# CITY OF ALBUQUERQUE

June 6, 2019

**RE: La Vida Liena**  
**10501 Lagrima de Oro Road NE**  
**Conceptual Grading and Drainage Plan**  
**Engineer's Stamp Date: 04/22/19**  
**Hydrology File: F21D028**

Based upon the information provided in your submittal received 04/22/2019, the Conceptual Grading Plan and Drainage Report **is not** approved for action by the DRB for Site Plan for Building Permit. The following comments need to be addressed for approval of the above referenced project:

# CD-1

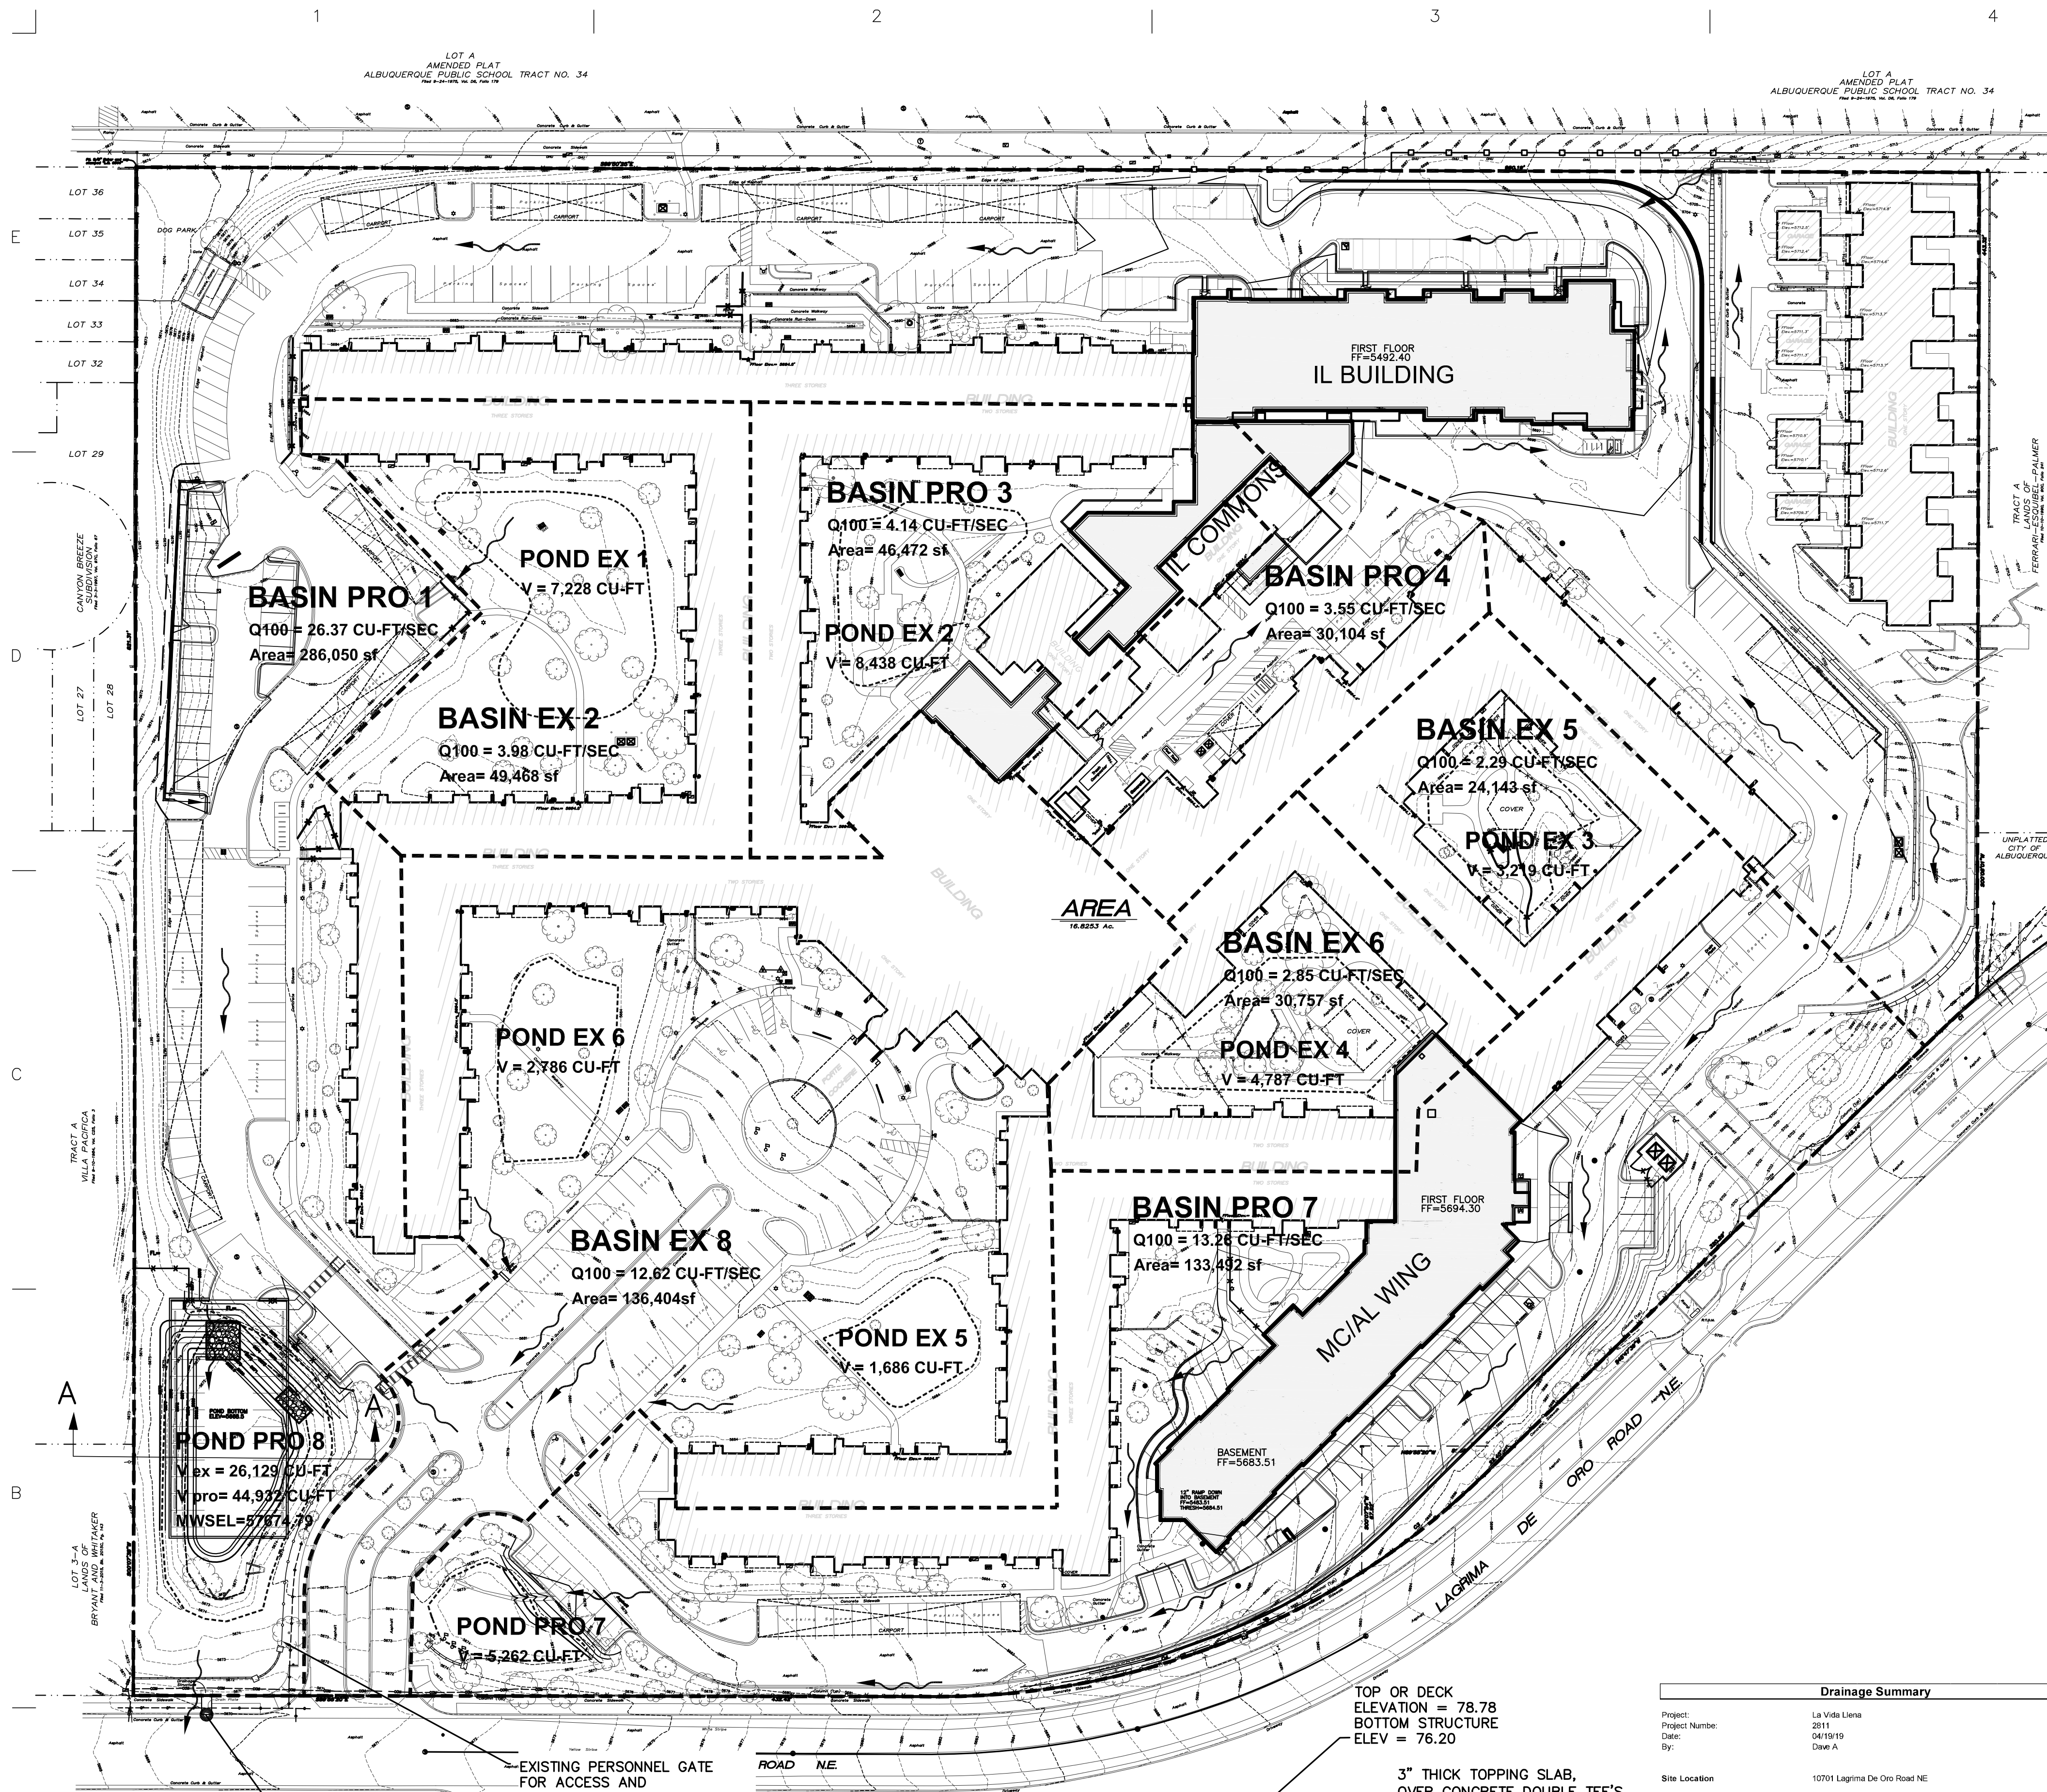
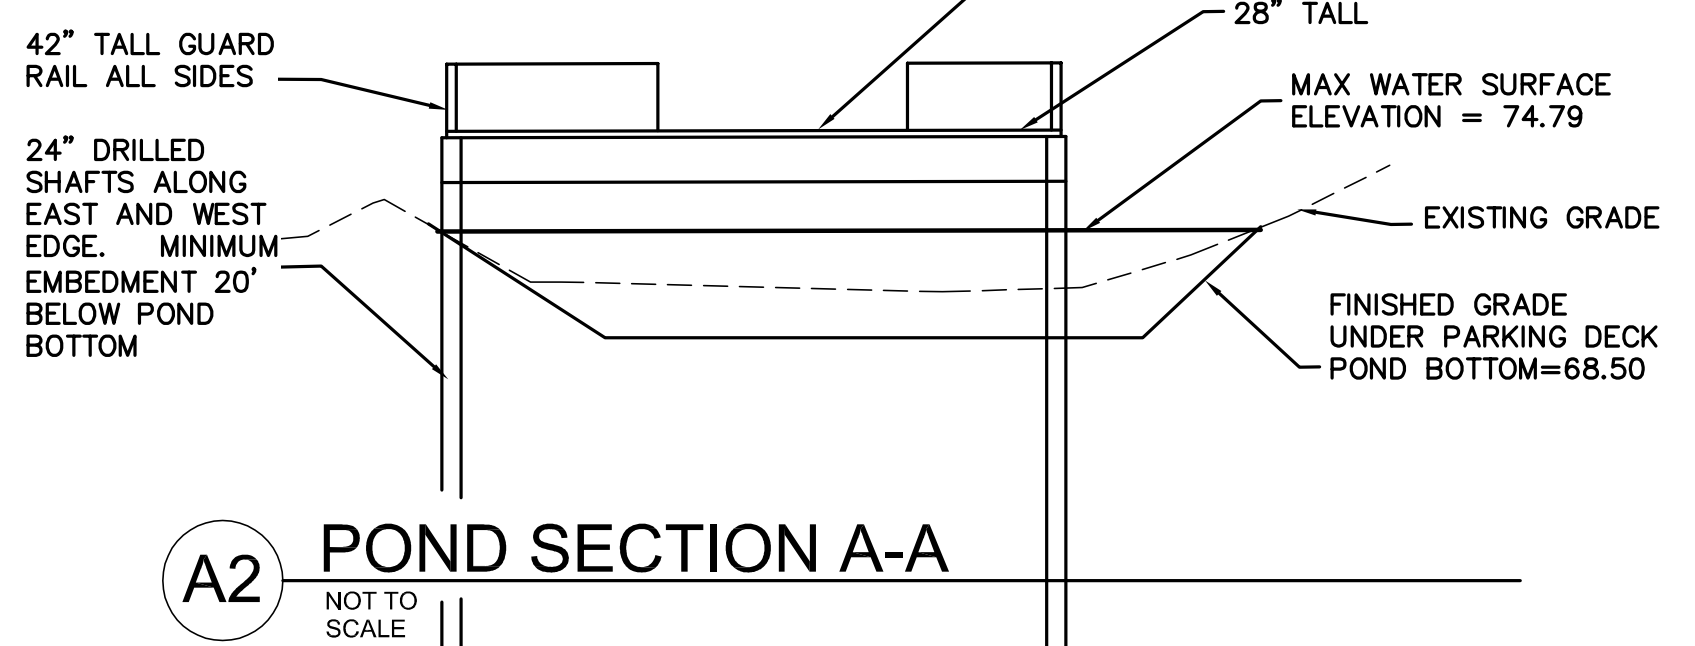
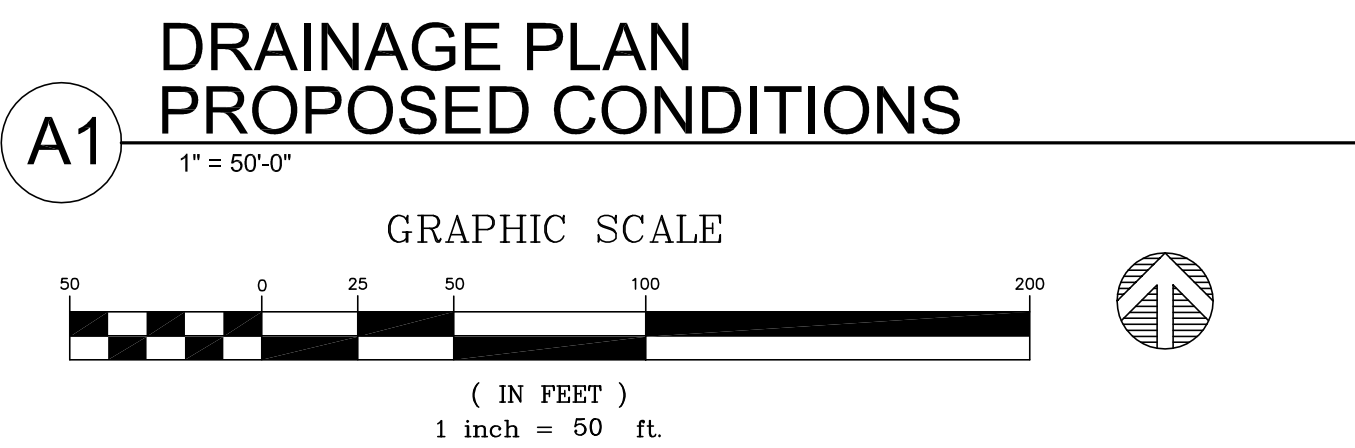
1. Sheet CD-1. Please remove the proposed parking structure over existing pond 8.
2. Sheet CD-1. Please add the information about the existing turn blocks in the wall for the emergency overflow for existing pond 8. See photo below.

3. Sheet CD-1. Please add a statement stating that you have physically verified the existing outfall structure in both the pond and within the ROW of Lagrima de Oro Road and have found it functioning as designed.

4. Please add an enlarge area for the proposed parking structure over existing pond 8. Also note how maintenance of existing pond 8 is to access the pond area.
